**Faraday House, Woodway Road, Sibford Ferris,
Oxfordshire, OX15 5RF**

23/02719/F

Proposal: Installation of external render system and stone cladding to existing house. Facing of the existing extension and garage in stone, externally insulating, re-roofing and creating new openings. The addition of a new garage building on the site of an old large shed.

Drawing Title:
Proposed South and West Elevations

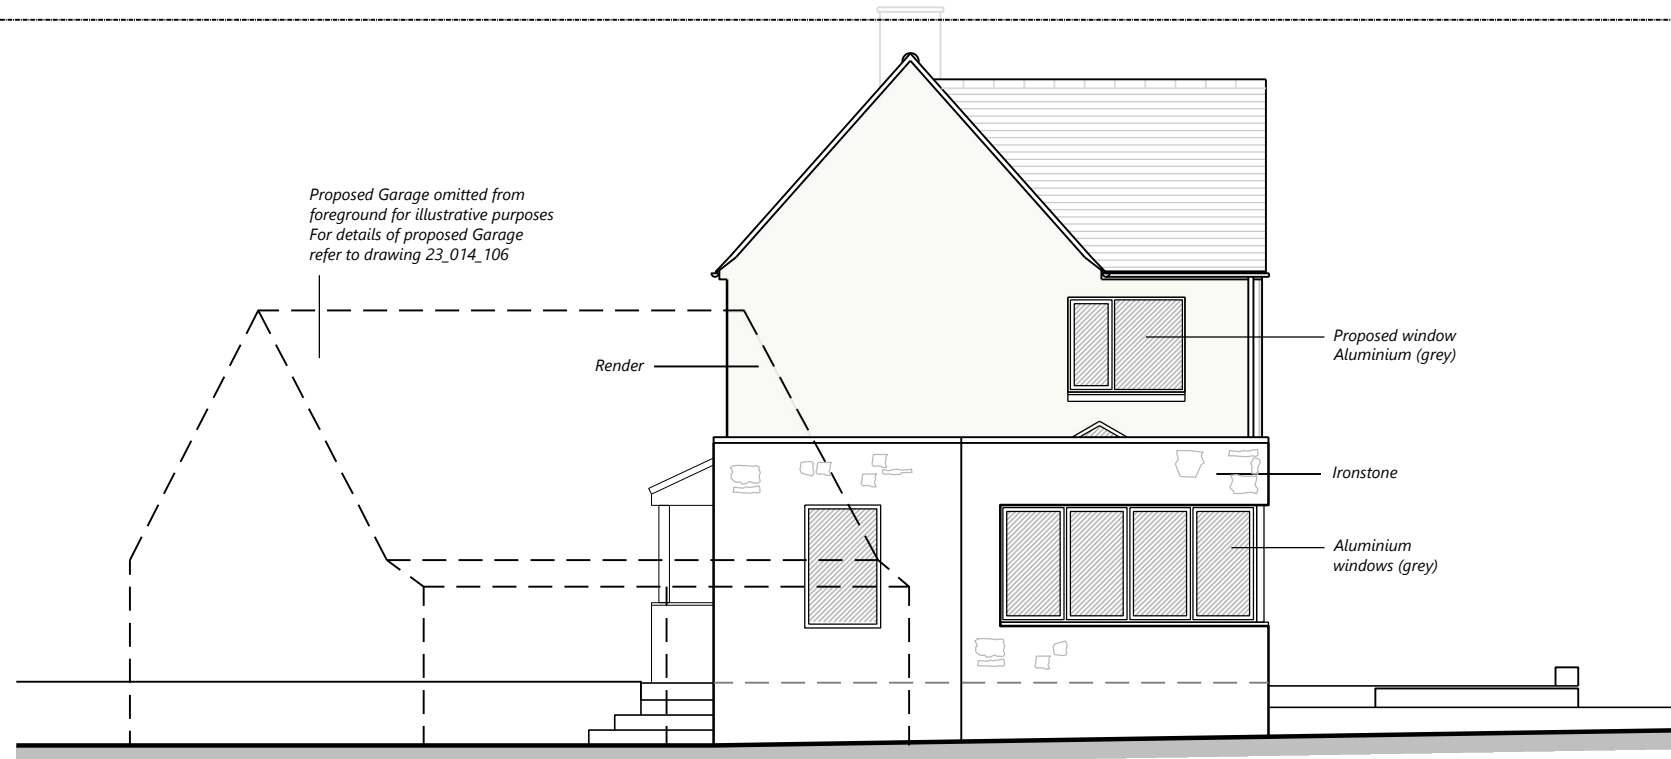
- The proposed works would involve all of the main dwelling's external elevations being renovated and finished in a combination of natural stone (ground floor) and render (first floor).

- The amended proposal, for a combination of natural stone and render, would result in an acceptable form of development in visual terms and indeed would provide for a significant improvement on the character and appearance of the existing dwelling.

Drawing Title:  
Proposed Garage

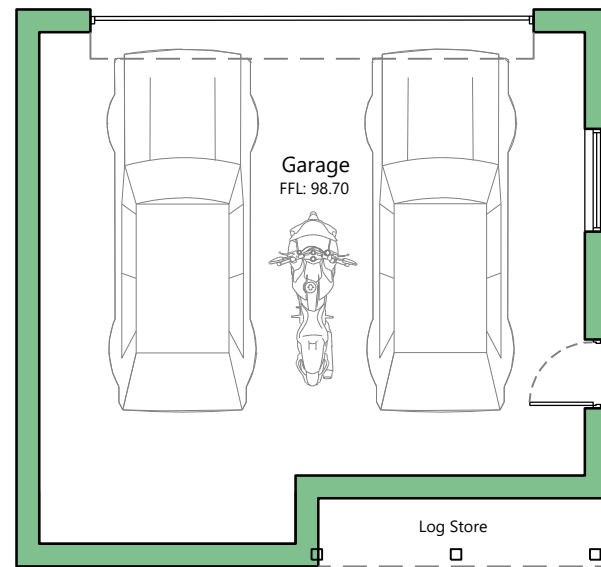
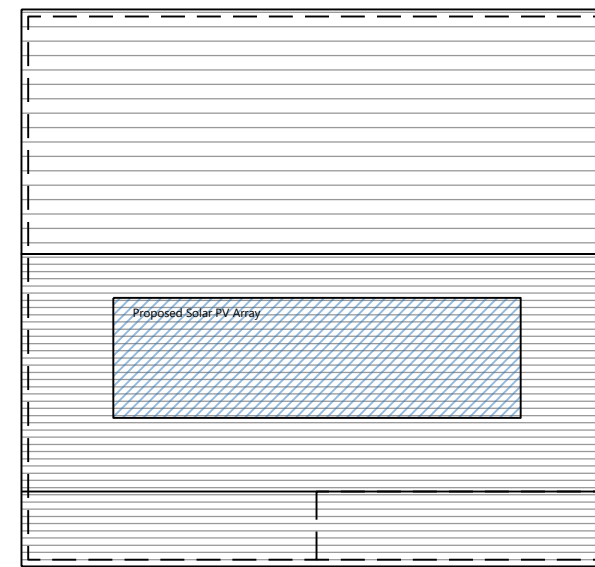
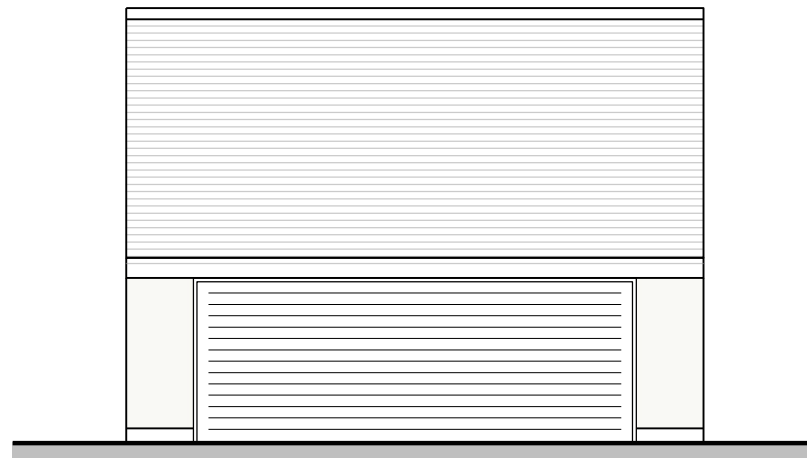
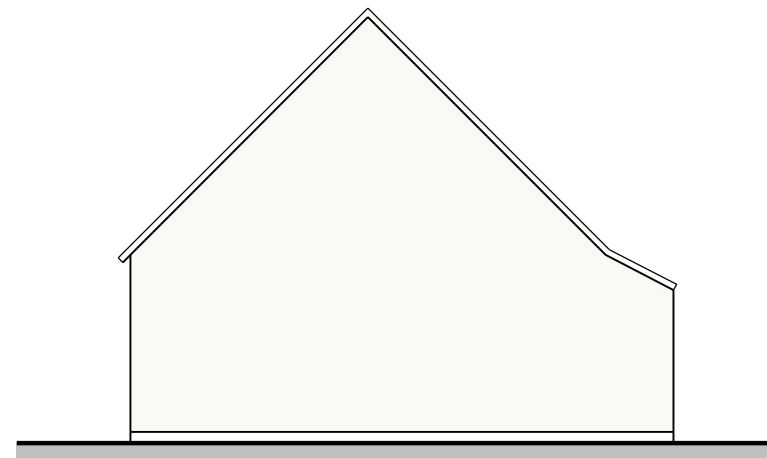
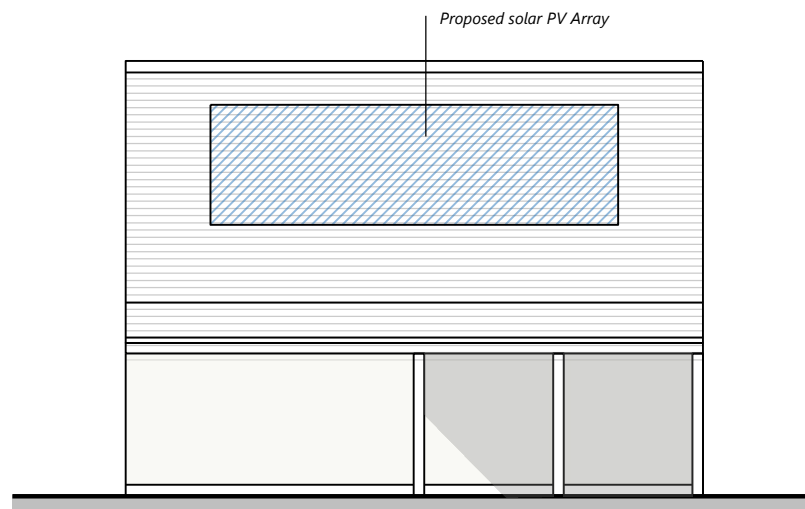
- With regard to the proposed garage, whilst it would be positioned in close proximity to the site's existing and sole access point onto and off the plot, it is considered that the proposed garage would not result in a visually prominent structure within the street scene.

- Permission was granted in the planning application prior (21/01277/F) for a double garage of a similar scale and siting, and thus the proposal is not considered unacceptable with regard to its position or size.
- Overall, the amended proposal would not adversely affect the character or appearance of the area, and is therefore considered acceptable in visual amenity terms.

Drawing Title:
Proposed North and East Elevations

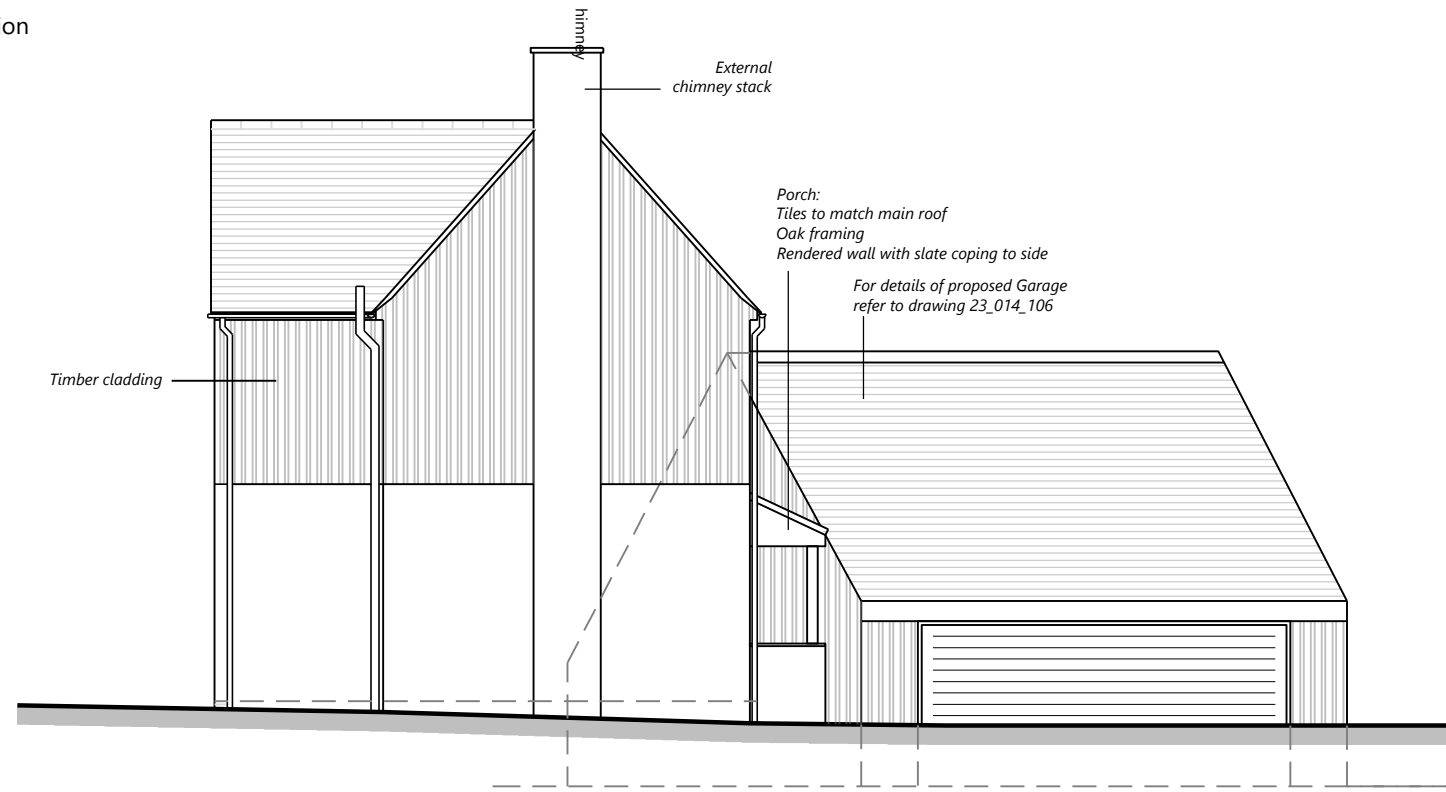
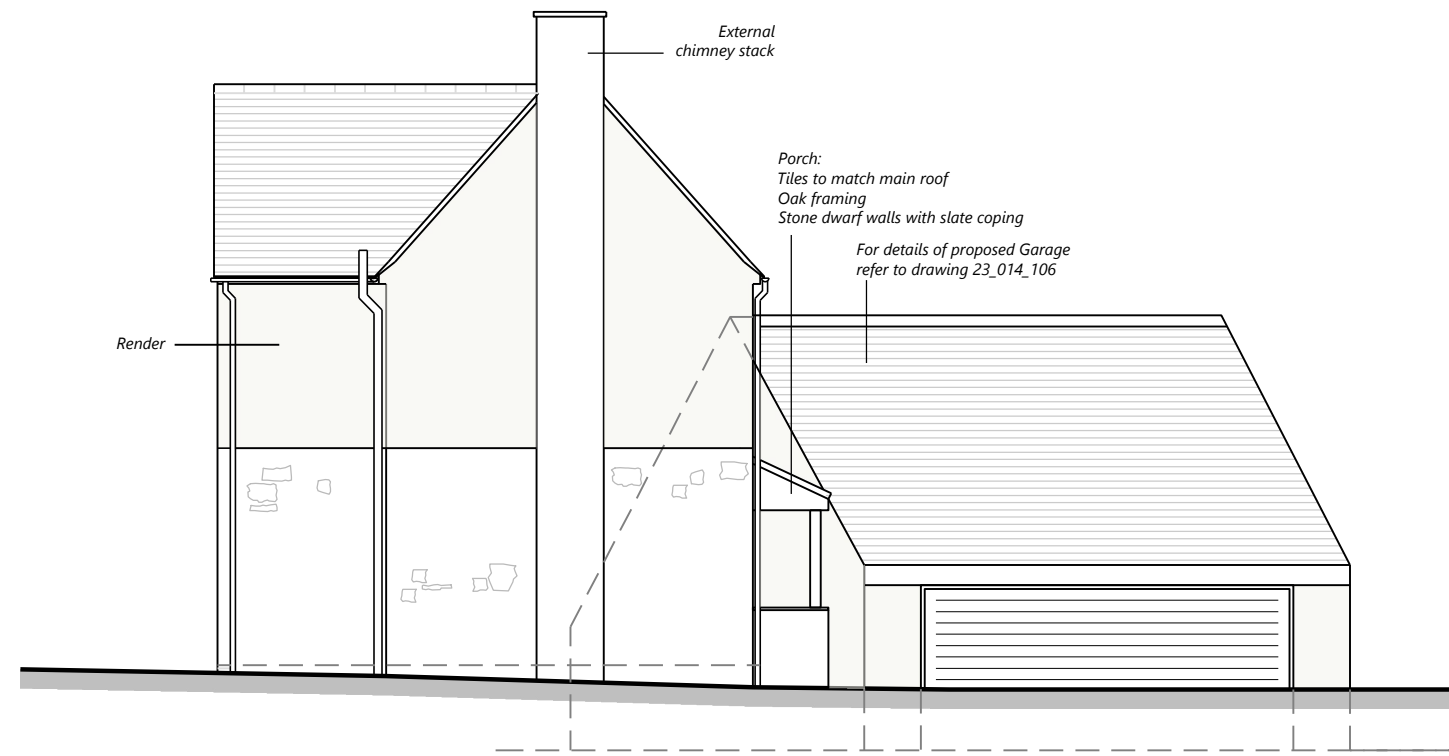
- It was considered that the originally submitted proposals for a considerable expanse of timber cladding would have had a very significant impact on the character and appearance of the area. The use of timber cladding is not supported by Cherwell in its Residential Design Guide, is not locally distinctive, and would result in a visually incongruous form of development.
